An  
Bord  
Pleanála

**Board Direction**  
**BD-005293-20**  
**ABP-305905-19**

The Board decided to refuse permission, generally in accordance with the Inspector's recommendation, for the following reasons and considerations.

Scale 1:50 @ A0

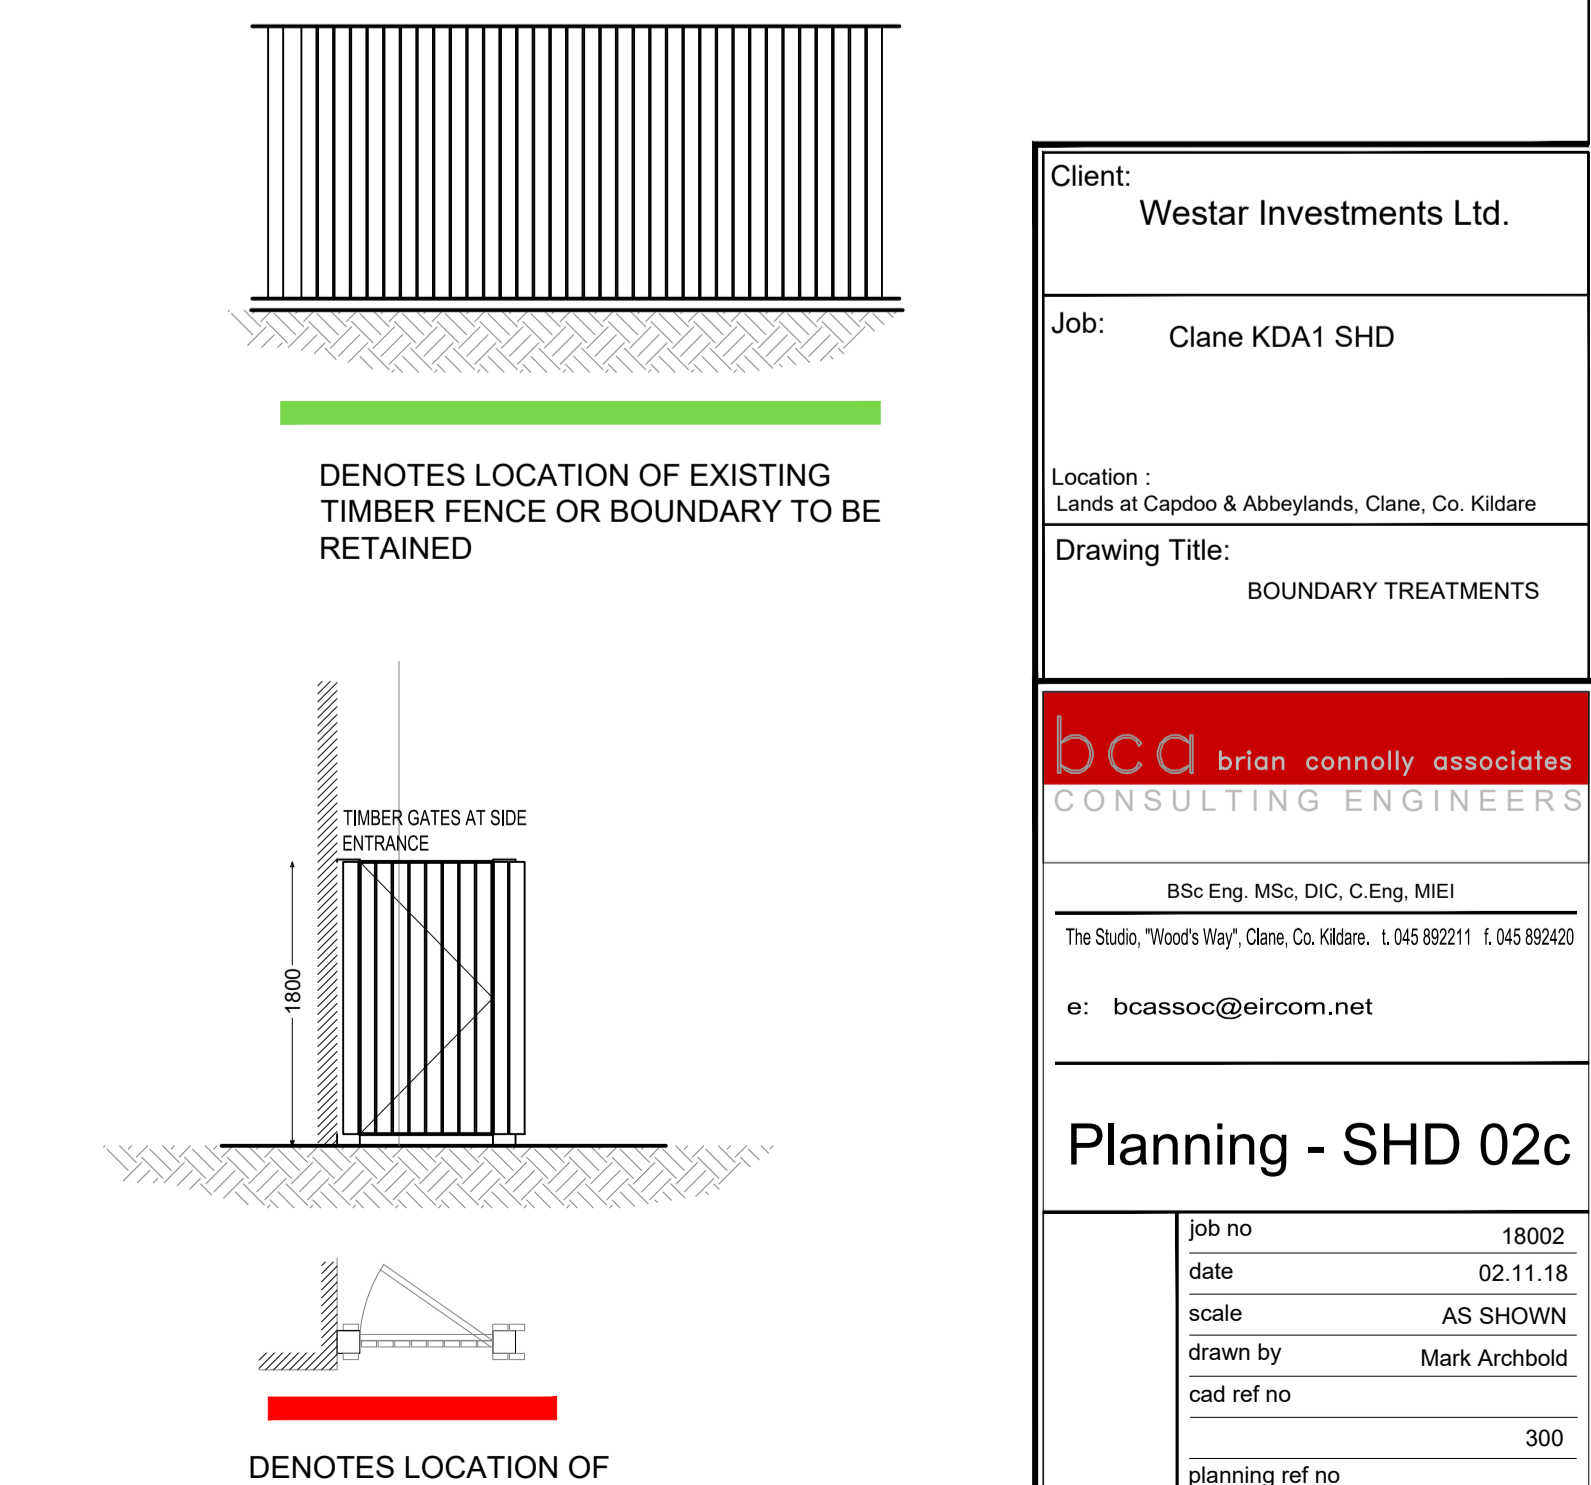
a high quality street layout that priorities people rather than vehicular movement. It is also considered that the development fails to integrate existing hedgerows satisfactorily into the layout of the development and, as such, would be contrary to objective GIO1.4 of the Clane Local Area Plan 2017-2023 which seeks to integrate hedgerows and trees into the design of new development. The proposed development would, therefore, seriously injure the residential amenities of future occupants, would be contrary to these Ministerial Guidelines and would be contrary to the proper planning and sustainable development of the area.

SITE LAYOUT-ROAD LAYOUT

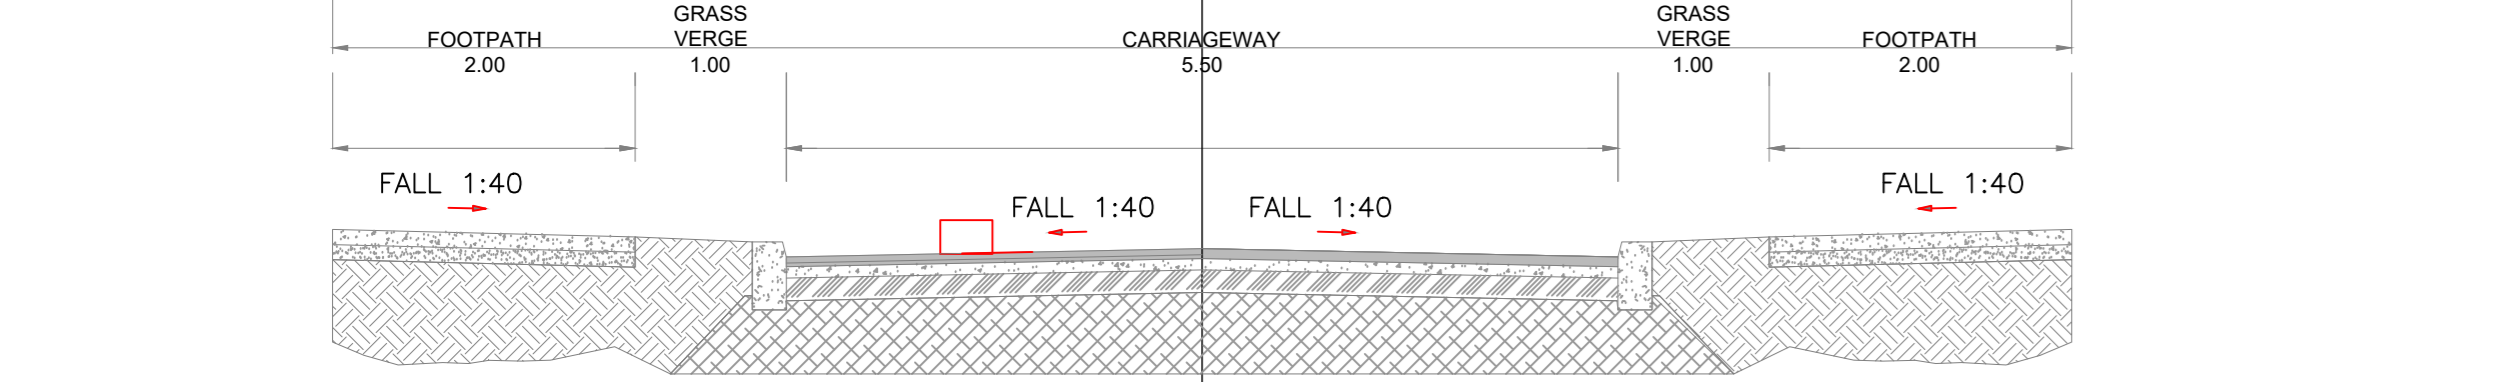
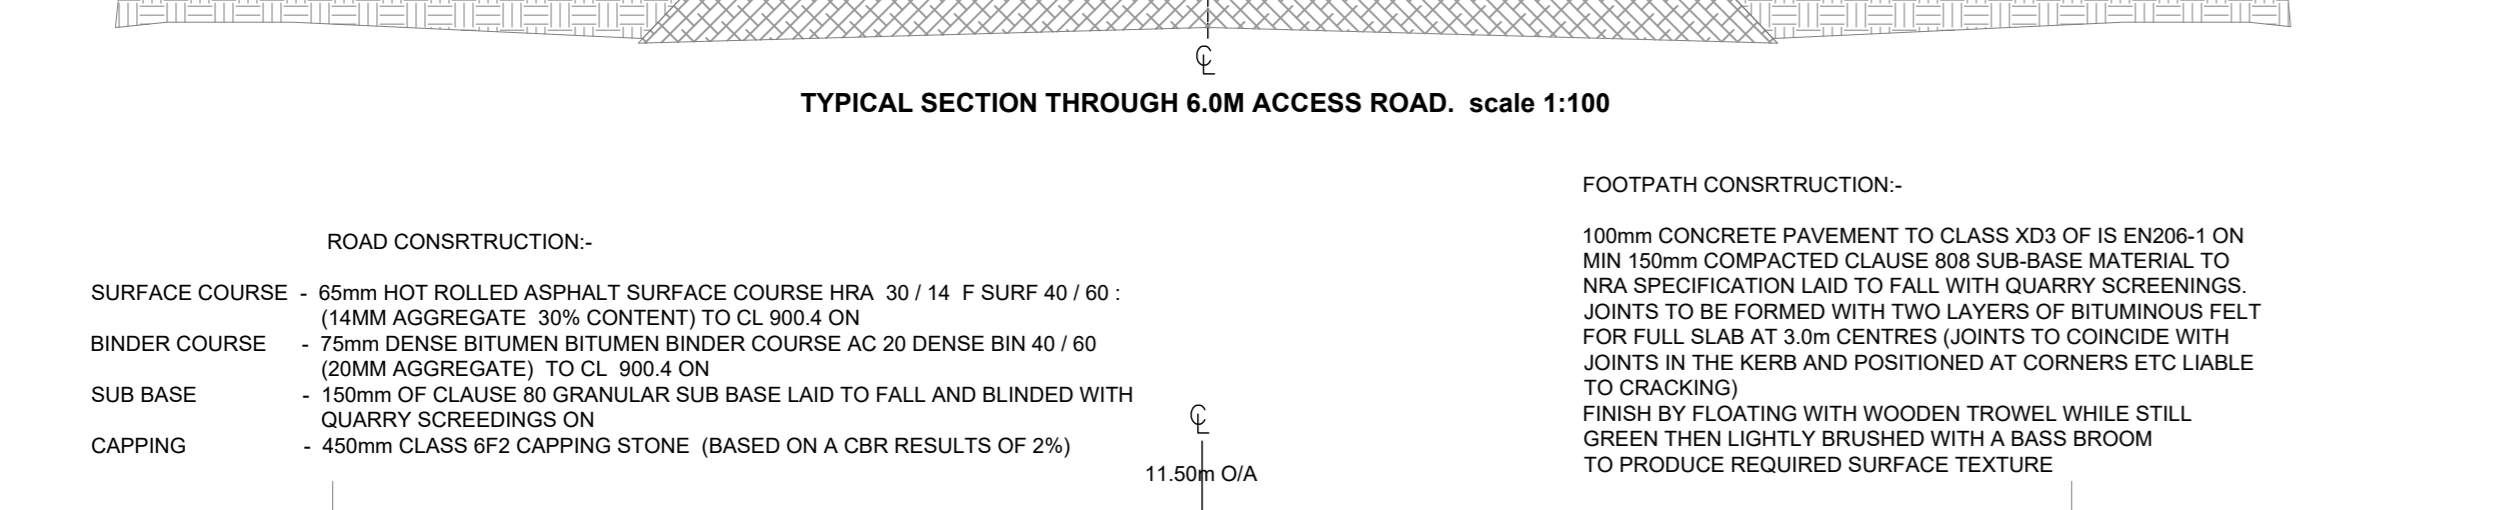
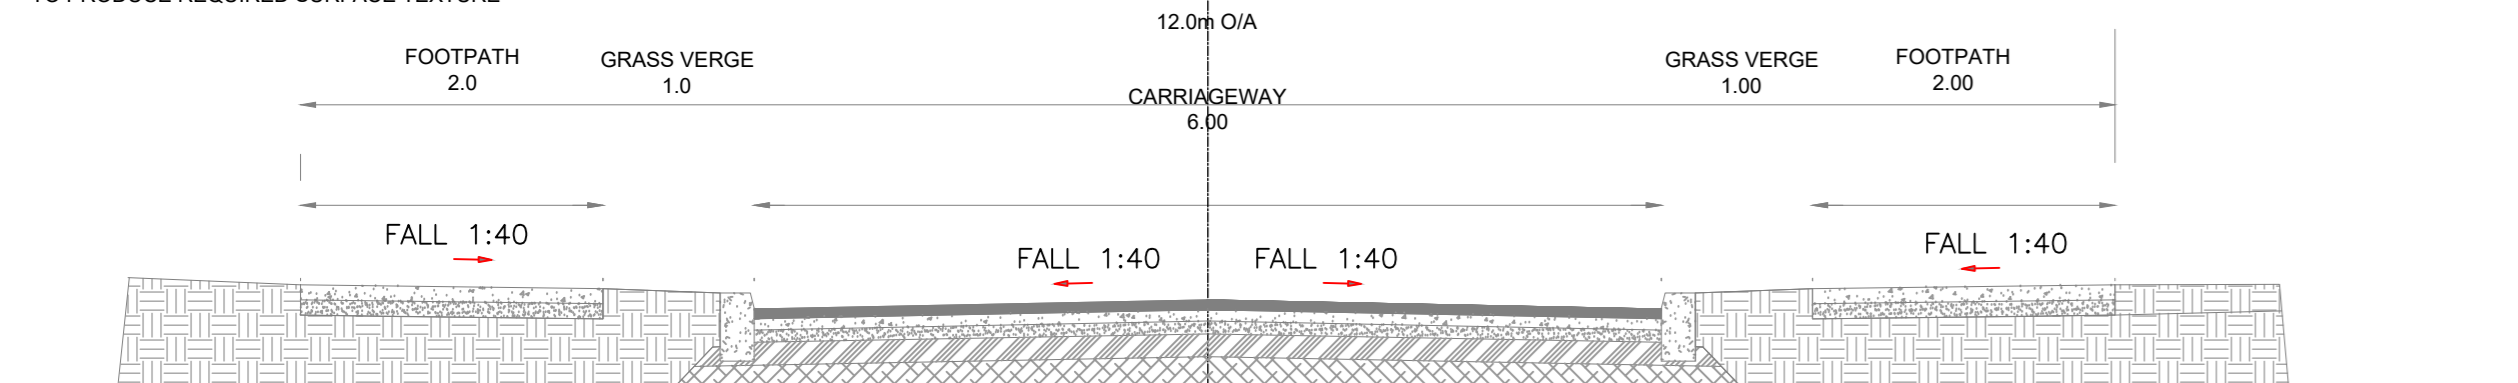
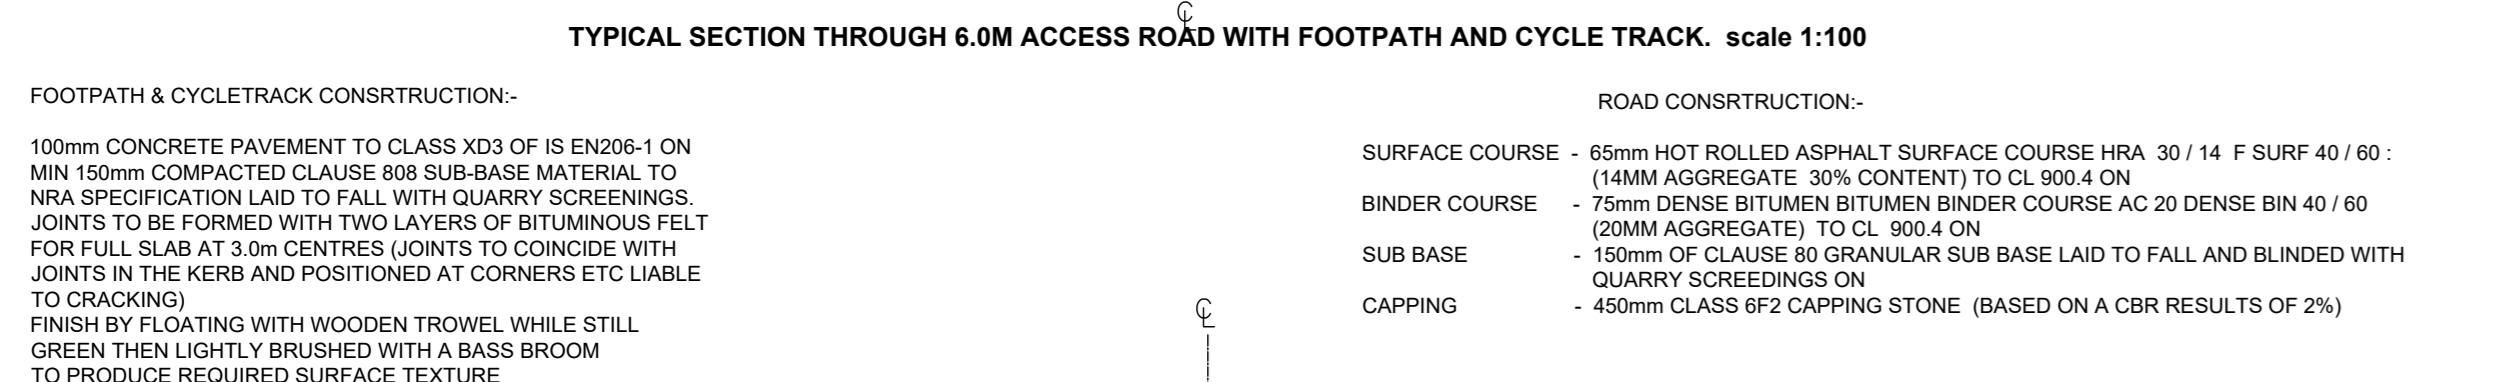
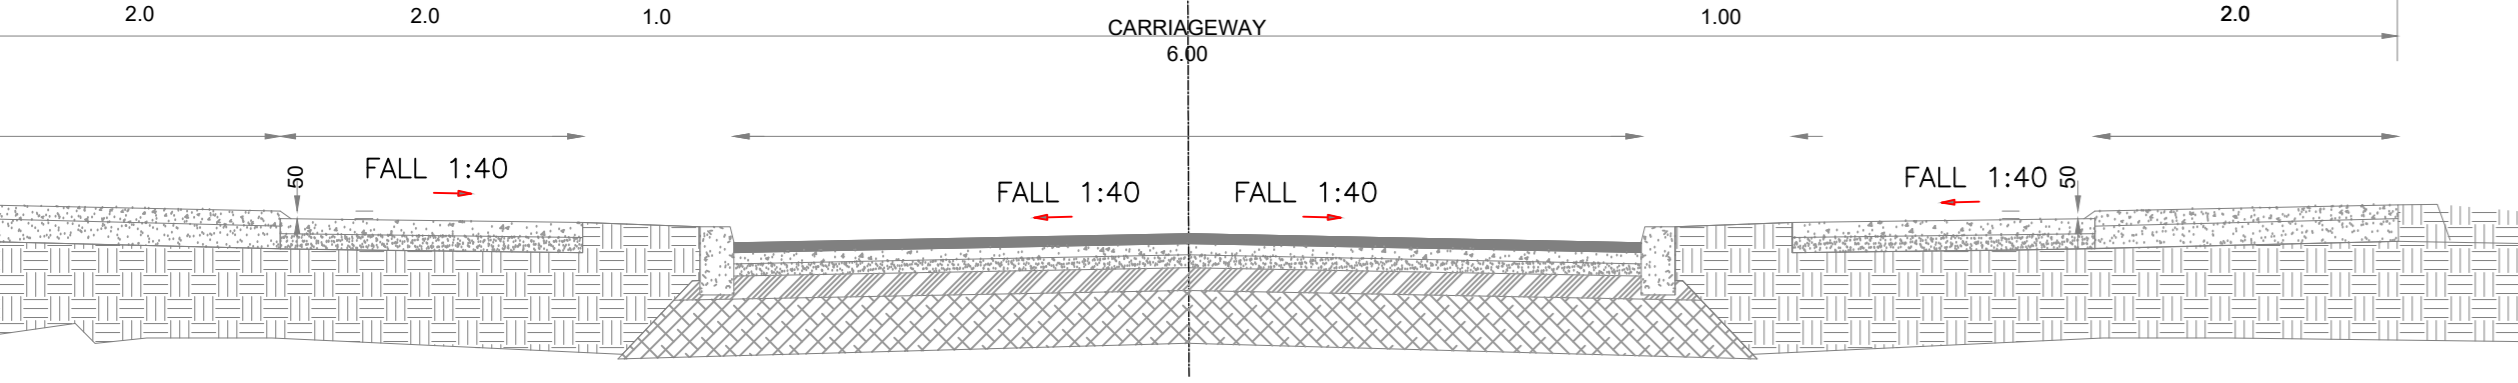
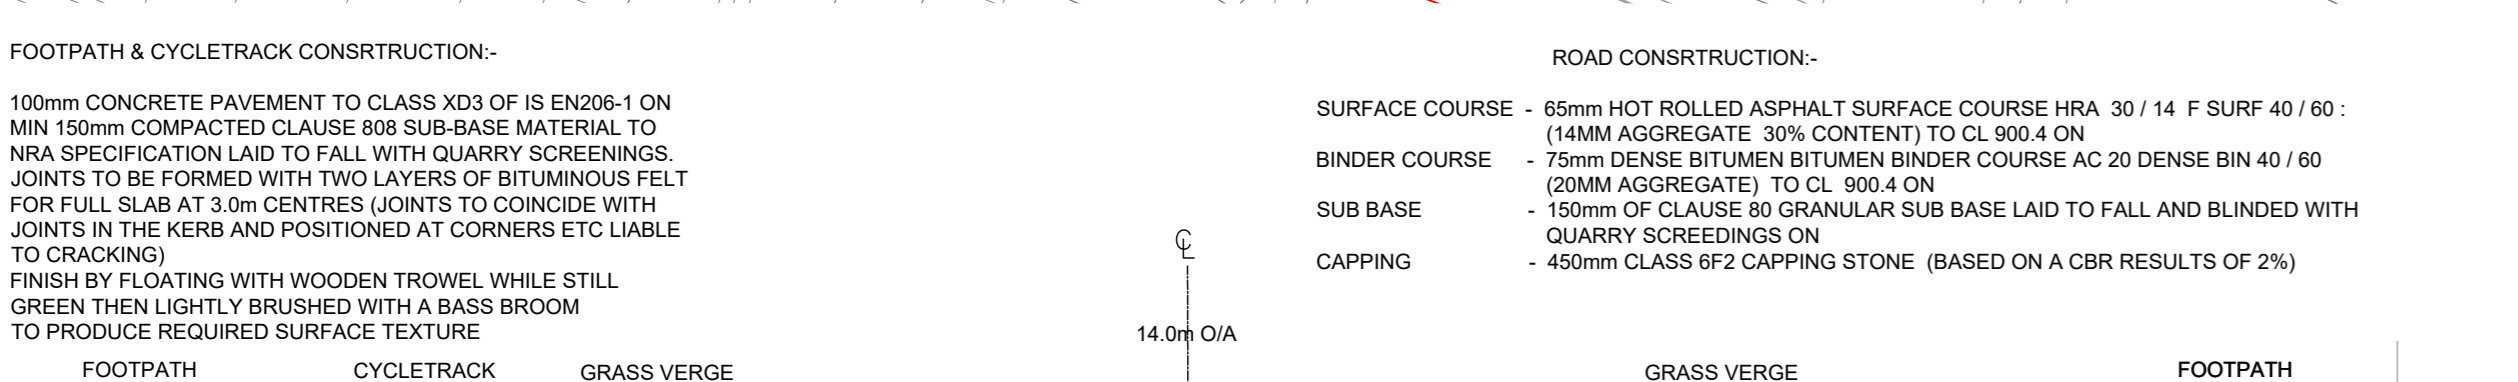
The "Urban Design Manual – a Best Practice Guide" issued by the Department of the Environment, Heritage and Local Government in 2009, to accompany the Guidelines for Planning Authorities on Sustainable Residential Development in Urban Areas includes key criteria such as context, connections, inclusivity, variety and distinctiveness. It is considered that the proposed development is dominated by roads and surface car parking and results in a poor design concept for the site that is substandard in its form and layout, fails to establish a sense of place, would result in a substandard form of development that lacks variety and distinctiveness and includes a poor quality of urban and architectural design, all of which would be seriously injurious to the residential amenities of future occupants and contrary to the provisions of the Urban Design Manual – a Best Practice Guide in particular criteria no. 6 Distinctiveness and no. 7 Layout and to Policy HD1 and Objective HDO 2 of the Kildare County Development Plan 2017-2023. In addition, the development fails to respond satisfactorily to the requirements of the Design Manual for Urban Roads and Streets issued by the Department of Transport, Tourism and Sport, and the Department of the Environment, Community and Local Government in 2013 as it does not promote
